Rezoning Petition Review

Rezoning Petition #: 08-116

Location of Property: Approximately 0.36 acres located on the intersection of Greenwood Cliff and Harding Place.

E. STORM WATER MANAGEMENT  
1. THE PETITIONER SHALL COMPLY WITH THE CHARLOTTE CITY COUNCIL APPROVED AND ADOPTED POST CONSTRUCTION CONTROLS ORDINANCE.

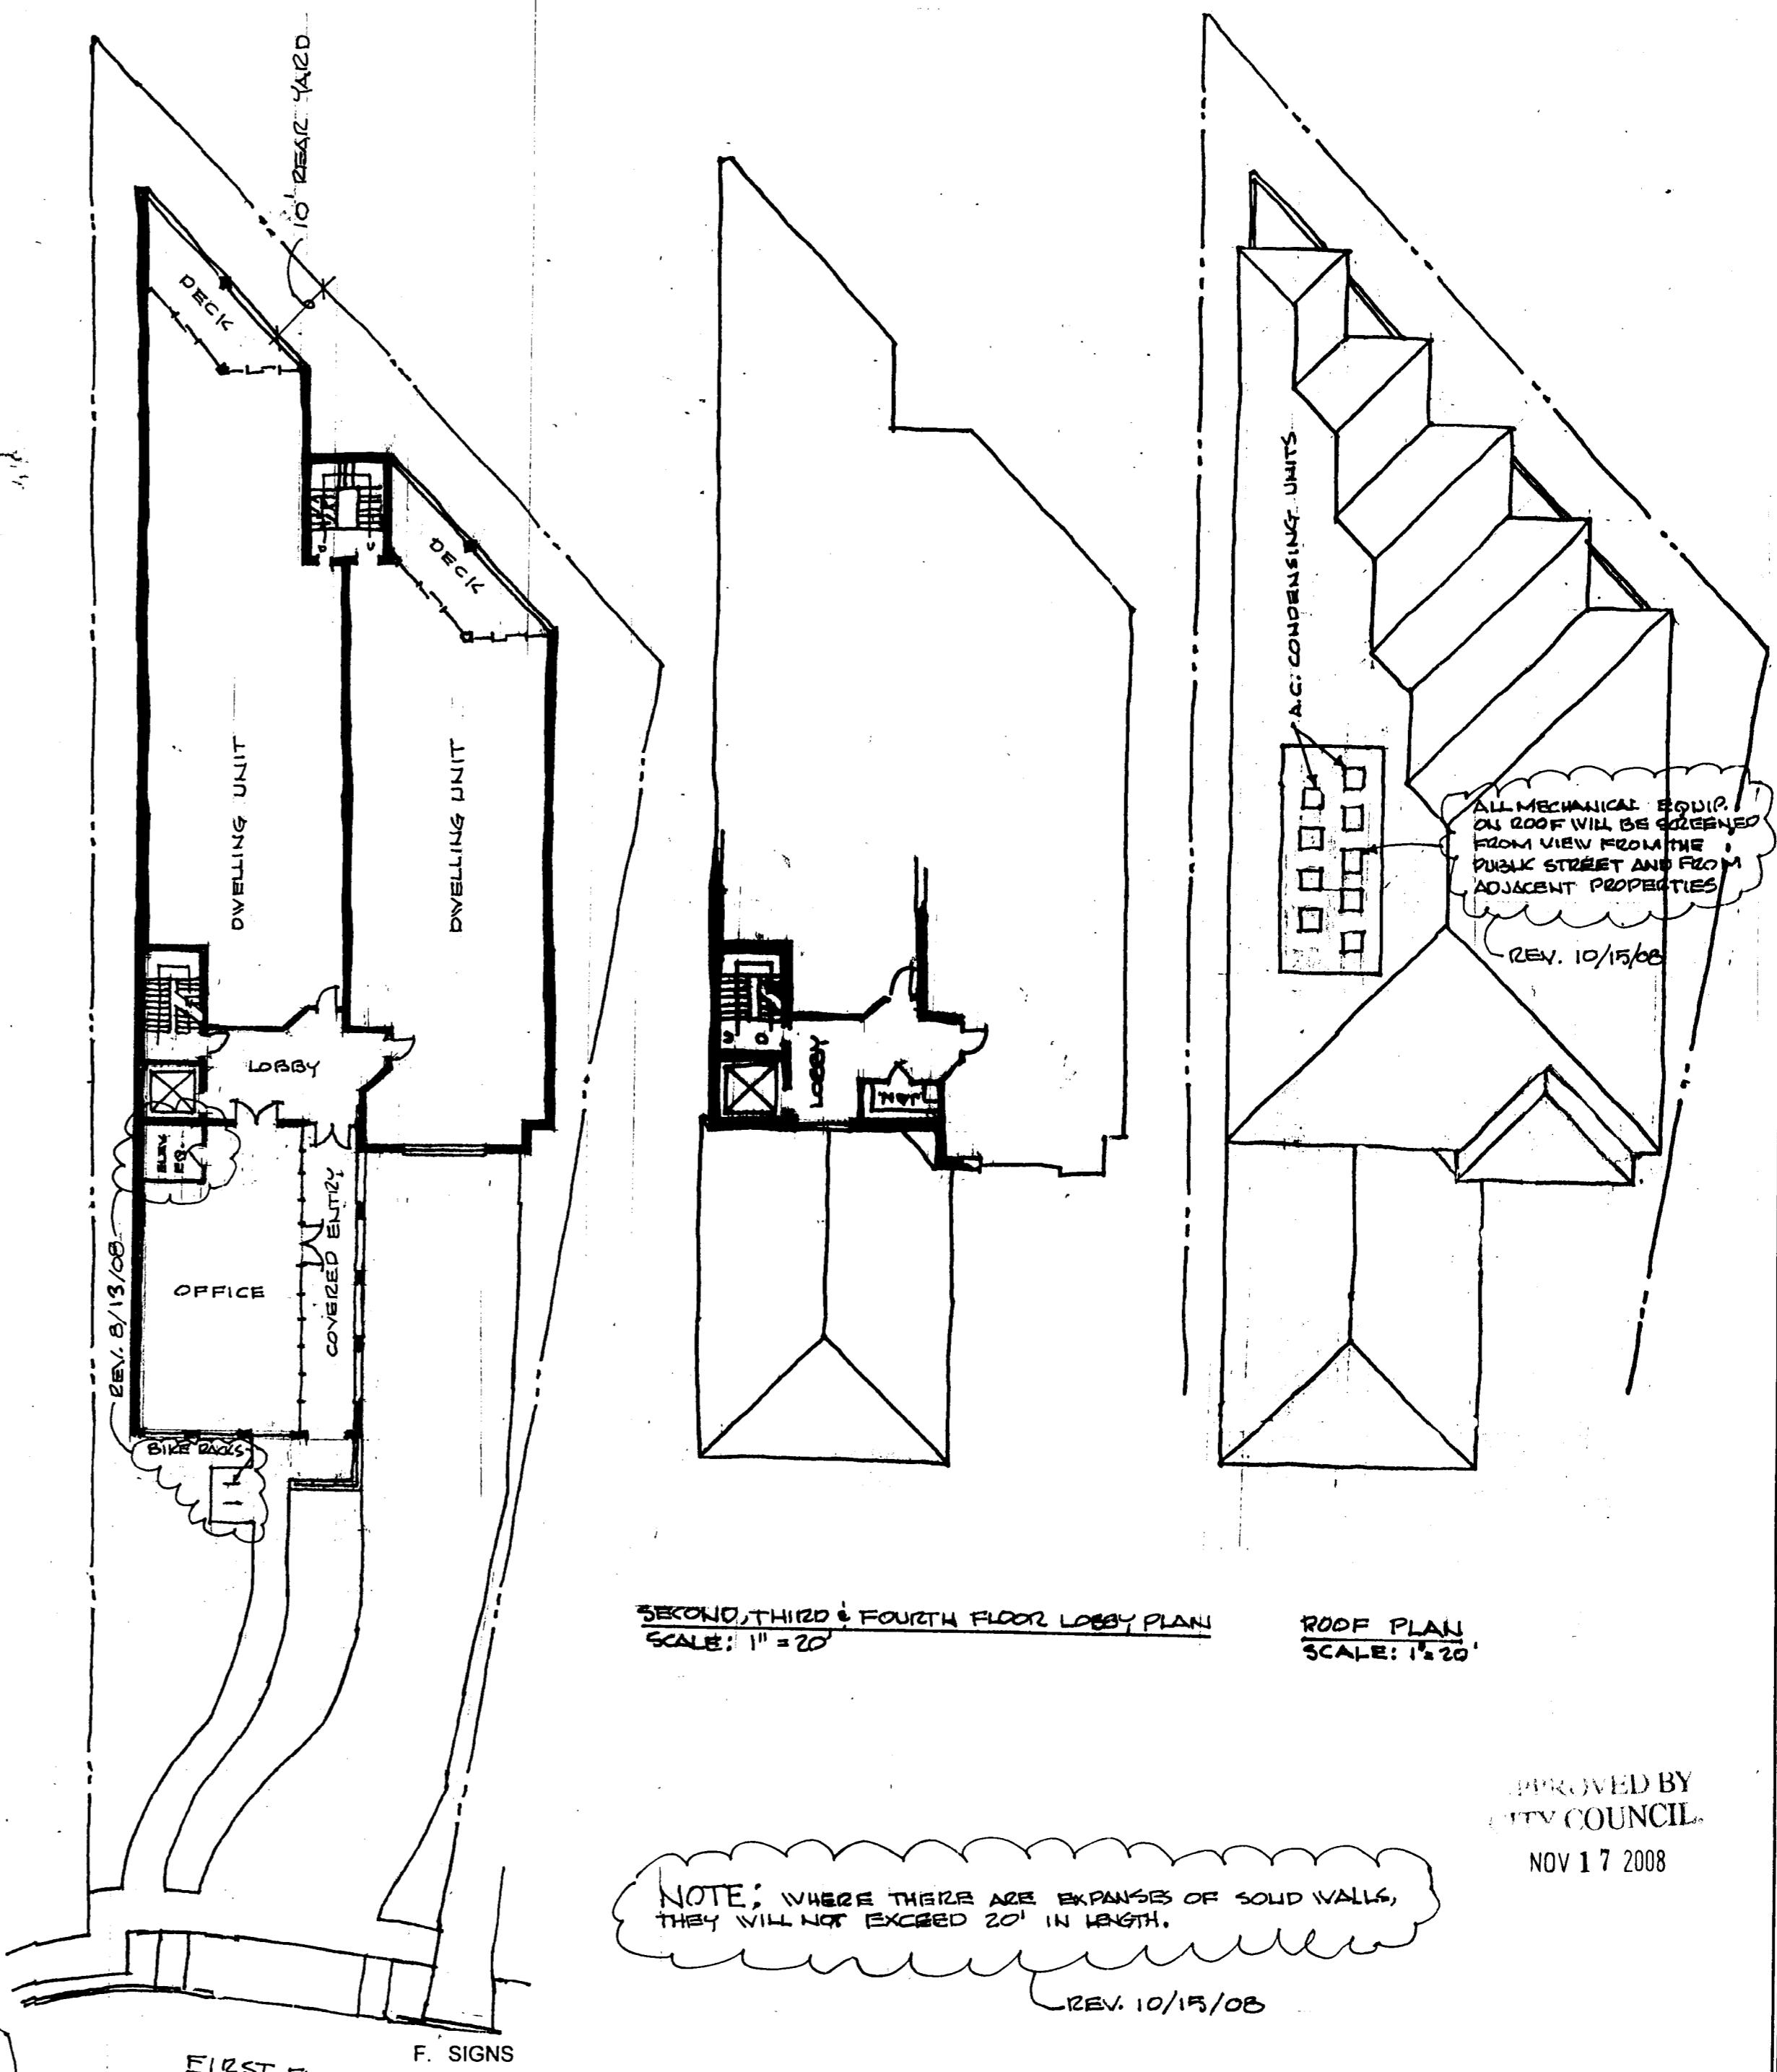
**Recommendations
Concerning Storm Water:** **Remove Note E parts #1 and #2 and add the following note**

The petitioner shall comply with the Charlotte City Council approved and adopted Post Construction Controls Ordinance.
